Consultation Response from: KC Environmental Health (Pollution & Noise Control)
2024/90792 - Former Whiteley Engineering Works Site, St. Peg Lane, Cleckheaton, BD19 3SH
Use of land for storage and fit-out of acoustic containers with generator units and associated electrical equipment, with reinstatement of former access to St. Peg Lane, erection of security fence and siting of security and welfare cabins
**Date Responded:
07 May 2024**
**Responding Officer:
MN and NH**
**Responding Ref:
WK/202410934**
Contaminated Land

Proposed Site Plan

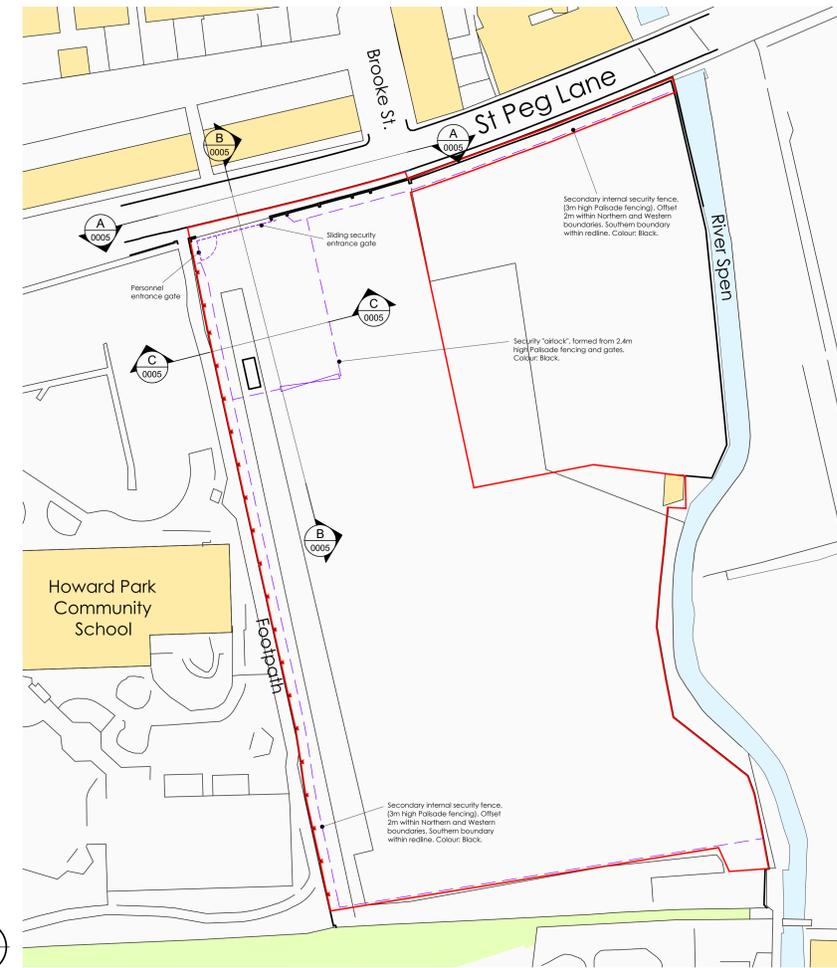
We acknowledge the submission of the report. We have reached out to the Planning Officer to seek clarification from the agent regarding the proposed groundworks, the foundation arrangements for all structures across site and service provisions to the proposed structures. We are also unclear about the electrical distribution pod identified on site. We require this information to continue our assessment of the application.
